**WELWYN HATFIELD BOROUGH COUNCIL  
EXECUTIVE DIRECTOR - PLANNING, PUBLIC PROTECTION AND GOVERNANCE**

**Application No:** 6/2020/3010/LAWE  
**Location:** 51 Kentish Lane Hatfield AL9 6NG  
**Proposal:** Certificate of lawfulness for the existing outbuilding  
**Officer:** Ms Lois-May Chapman

**Recommendation:** Refused

Drawing Number: TDC068/PL/300
 Scale: 1:50 (A1)

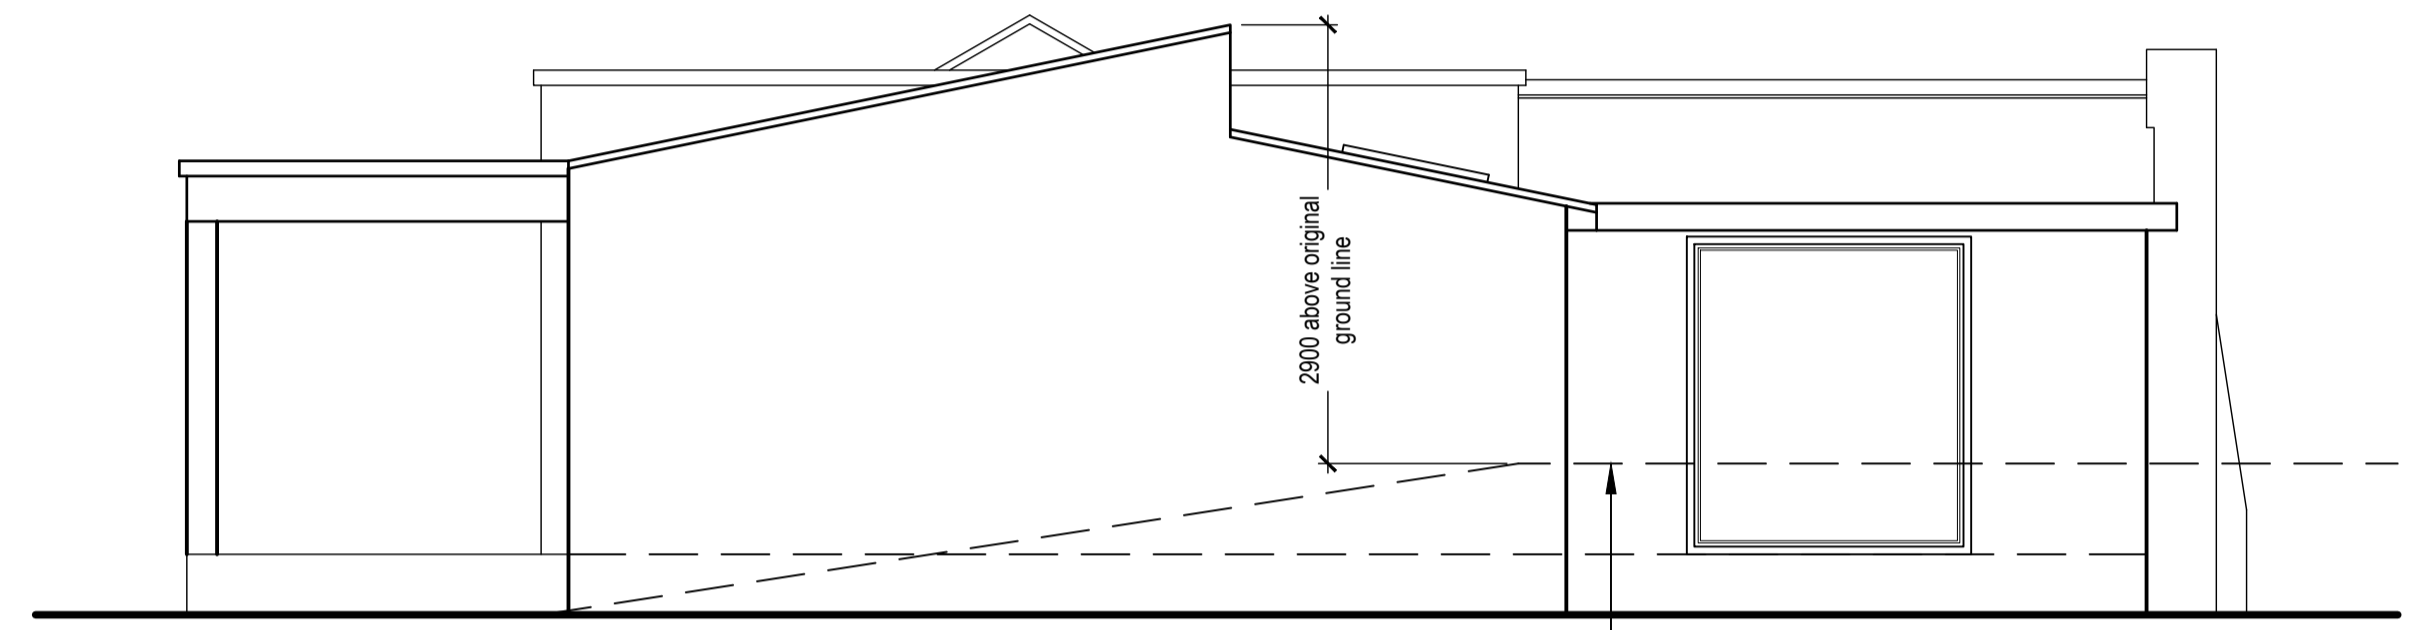
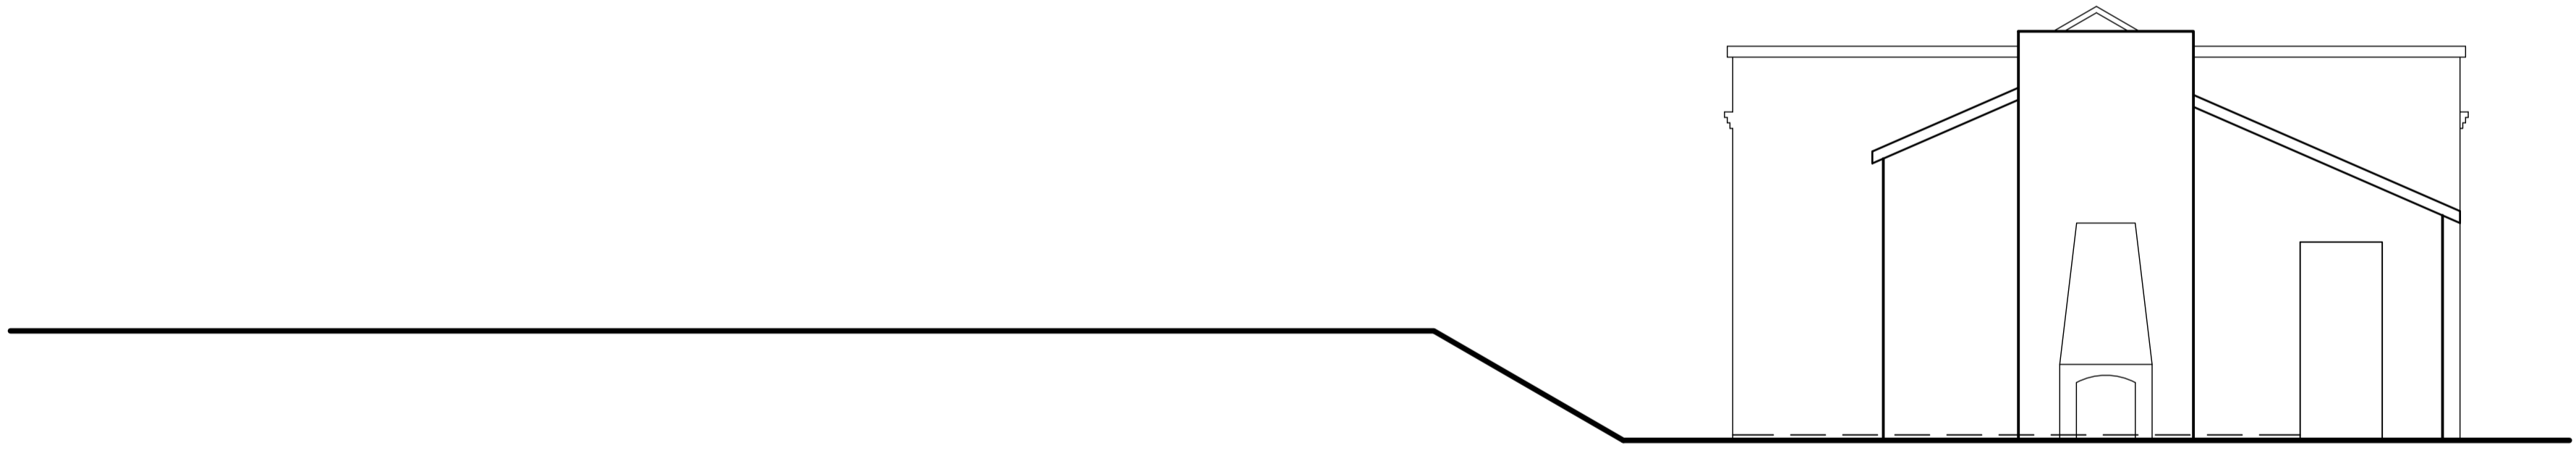
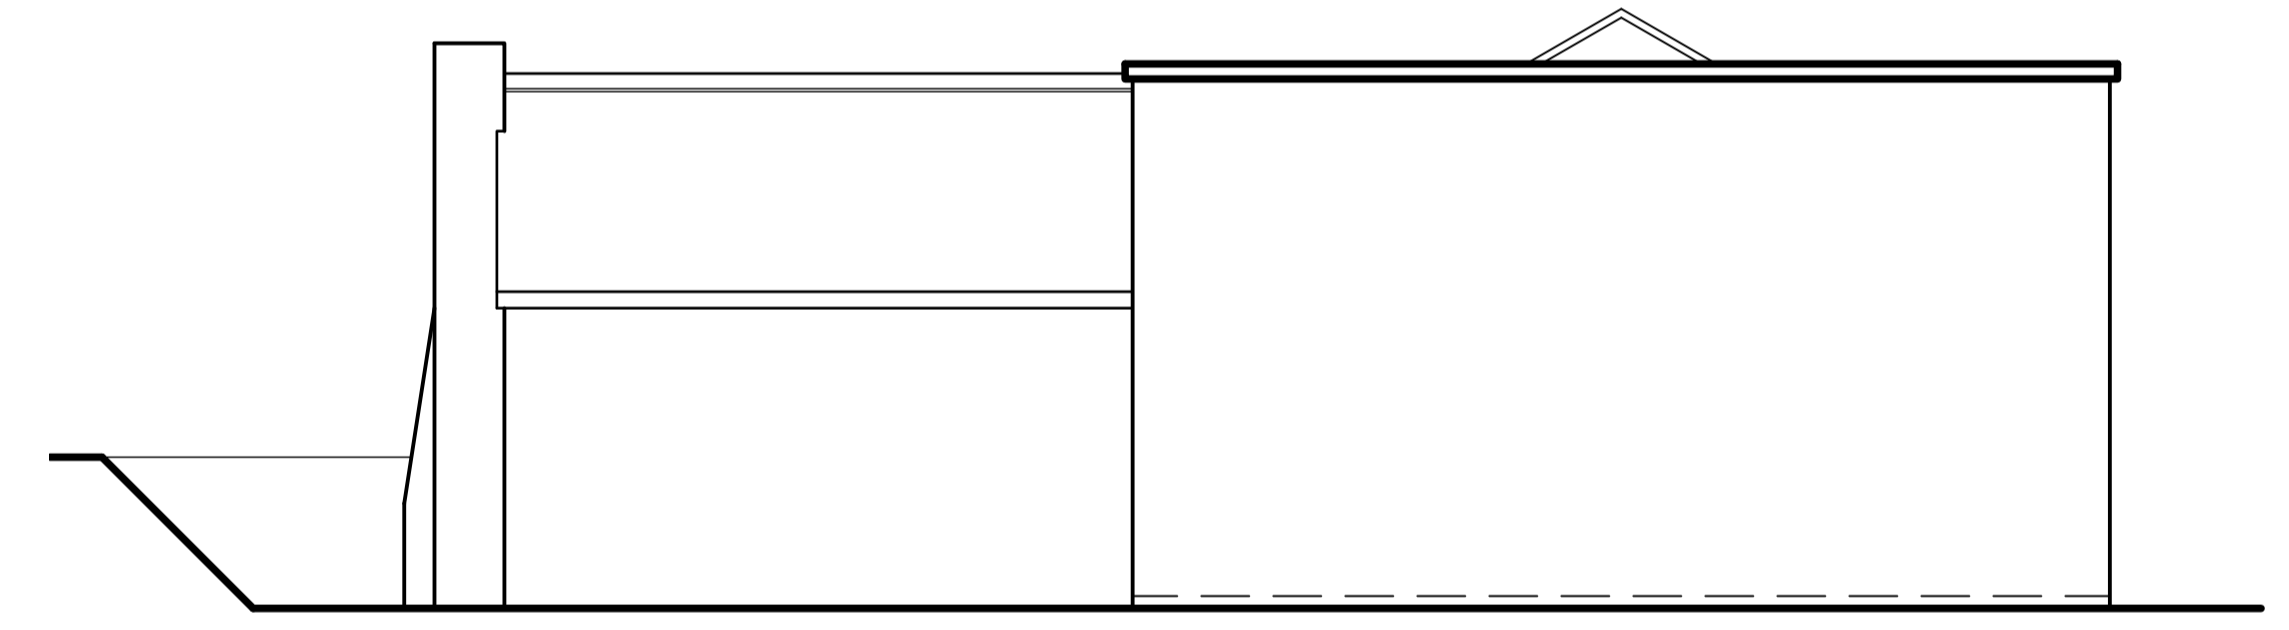
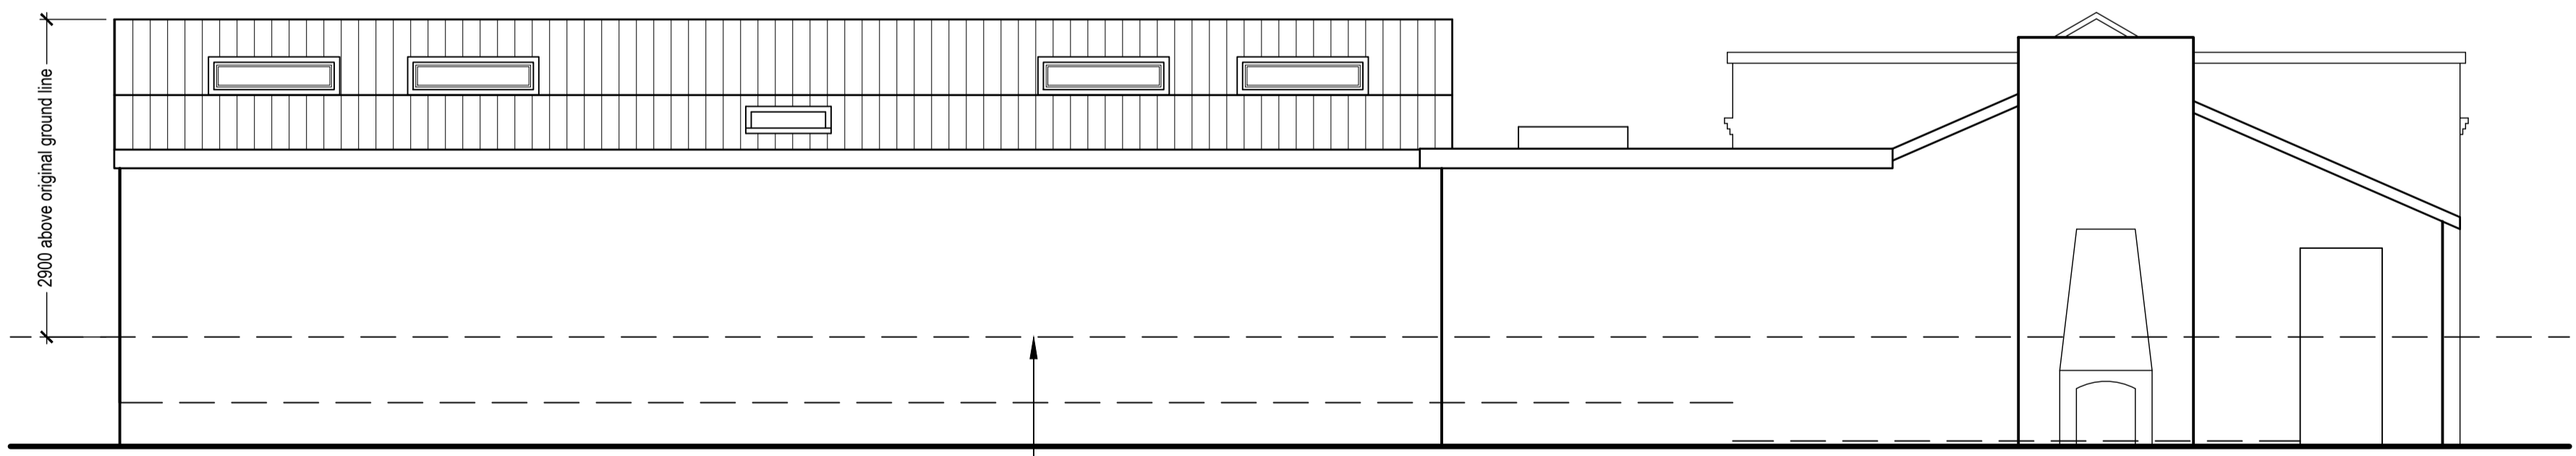
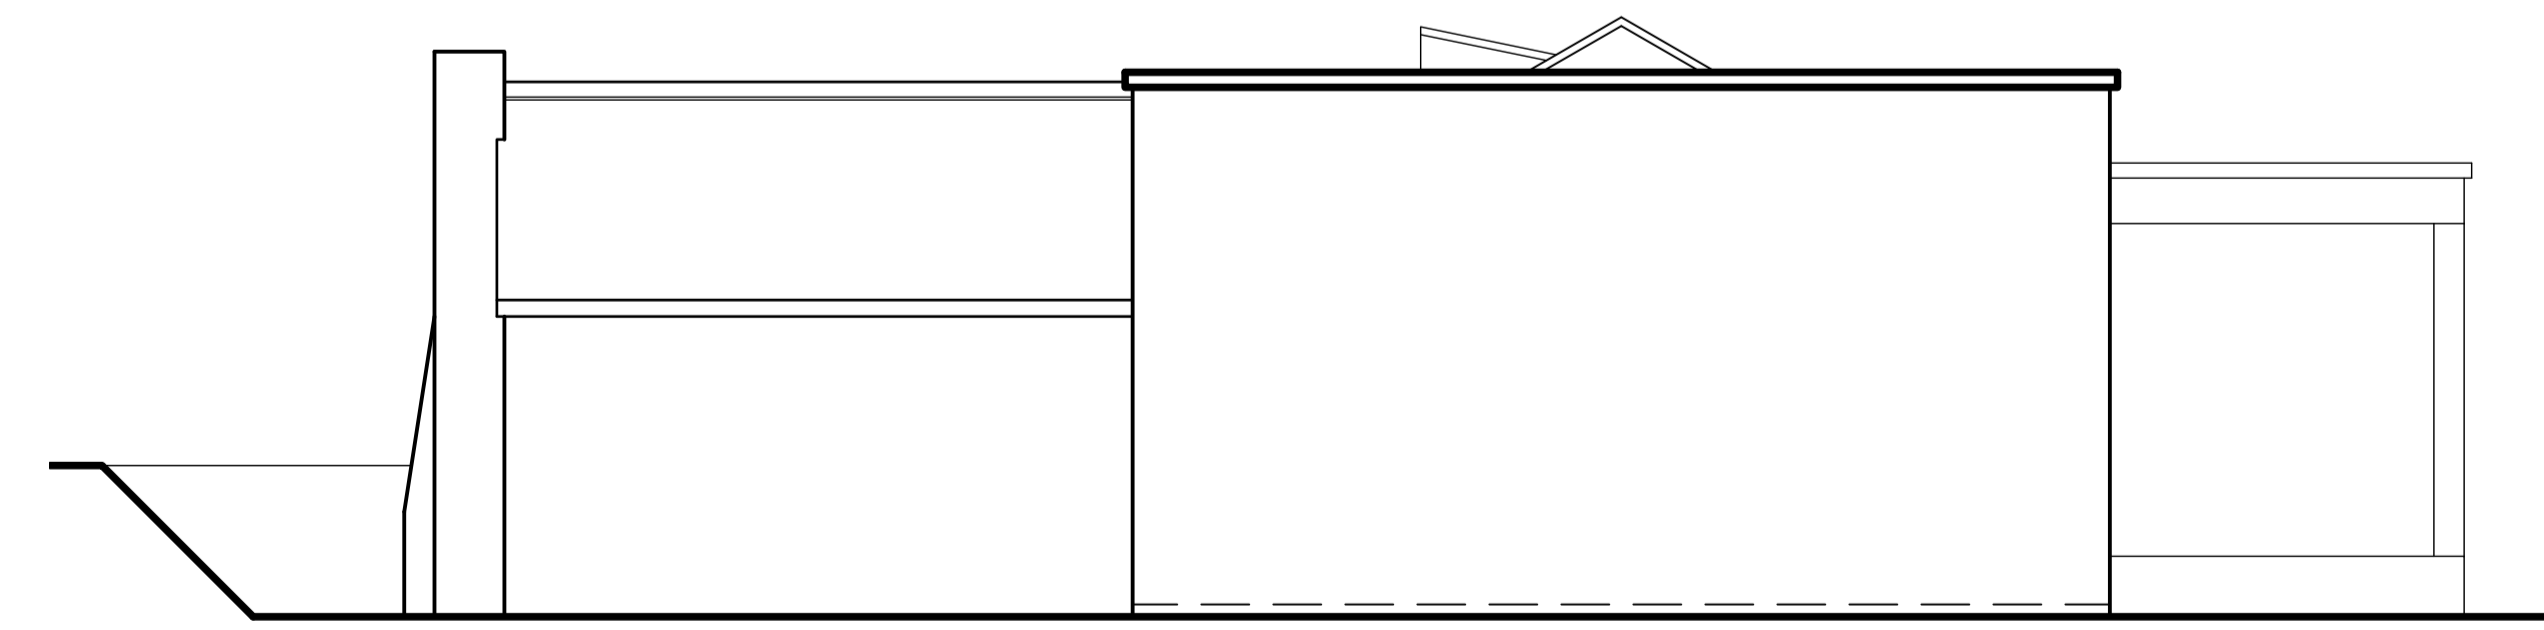
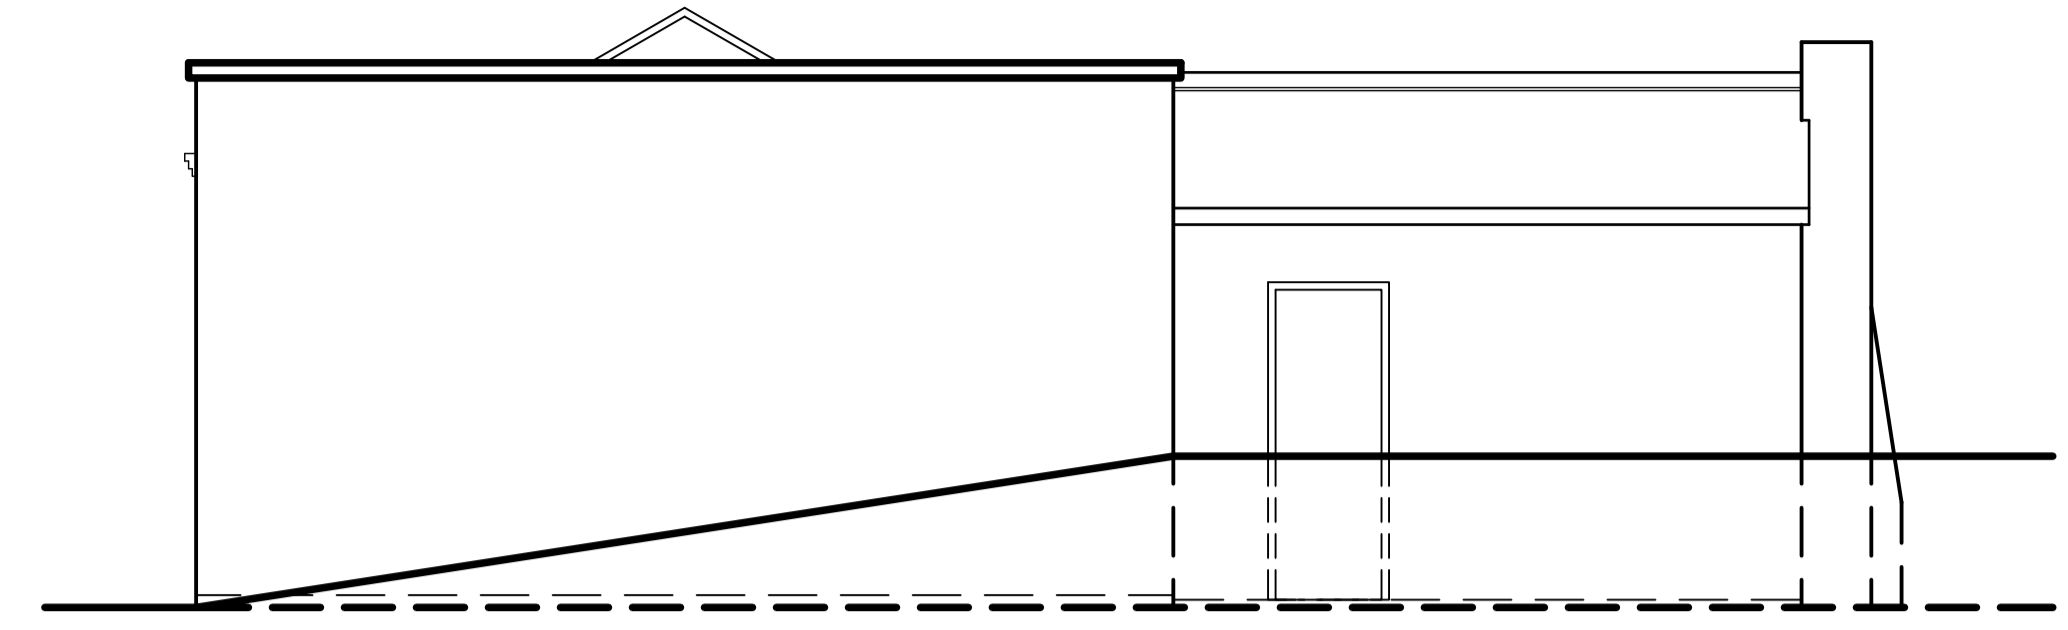
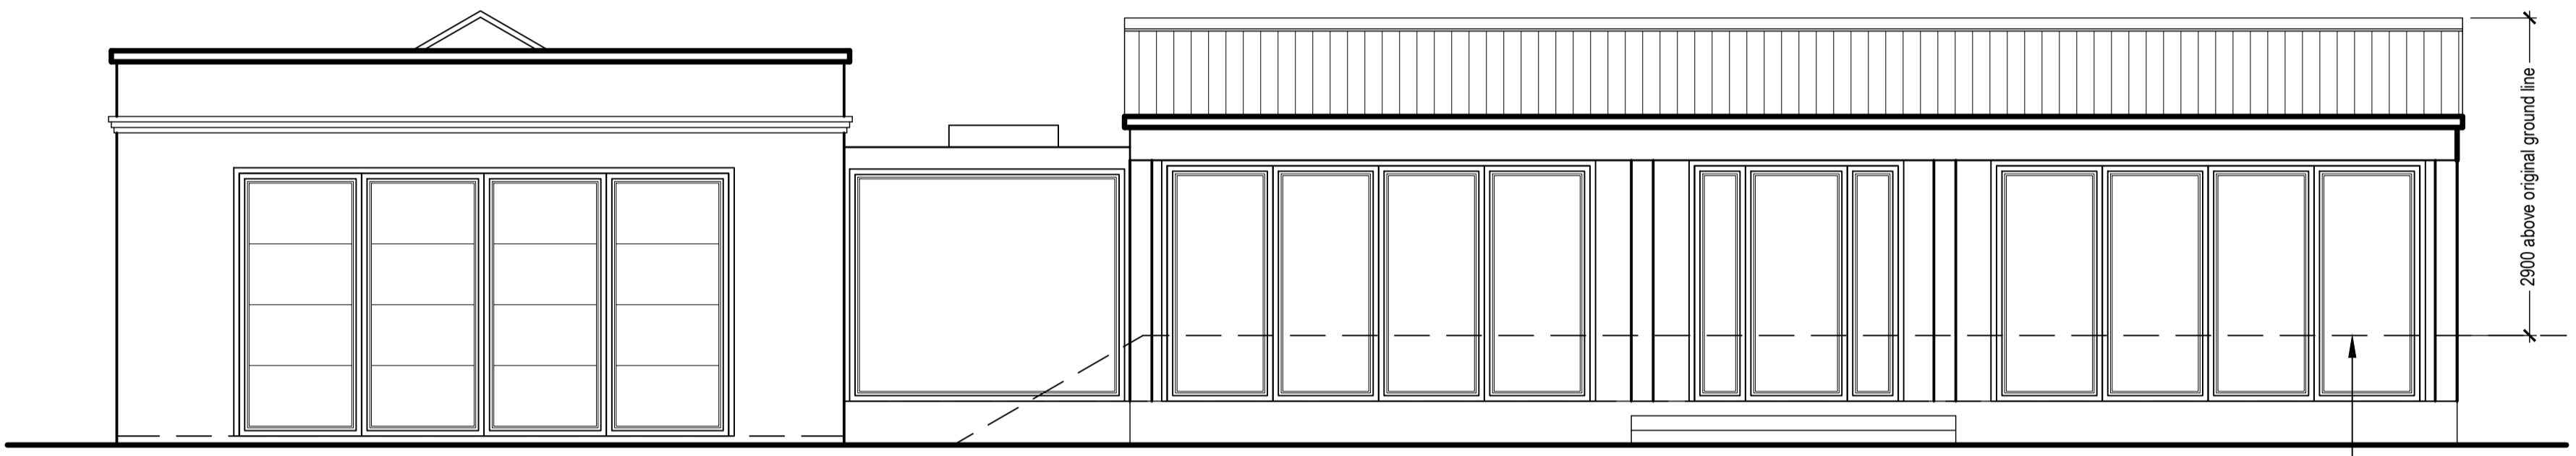
(d) the building would have more than a single storey;	<b>N</b>	N
(e) the height of the building, enclosure or container would exceed— (i) 4 metres in the case of a building with a dual-pitched roof, (ii) 2.5 metres in the case of a building, enclosure or container within 2 metres of the boundary of the curtilage of the dwellinghouse, or (iii) 3 metres in any other case;	<b>Y</b> -2.9m in height within 2m bounda ry	N

(f) the height of the eaves of the building would exceed 2.5 metres;	<b>Y</b> - 2.9m	N
(g) the building, enclosure, pool or container would be situated within the curtilage of a listed building;	<b>N</b>	N

(h) it would include the construction or provision of a verandah, balcony or raised platform;	<b>Y</b>	N
(i) it relates to a dwelling or a microwave antenna; or	<b>N</b>	N

The outbuilding includes the provision of a verandah which fails to comply with E.1 (h).
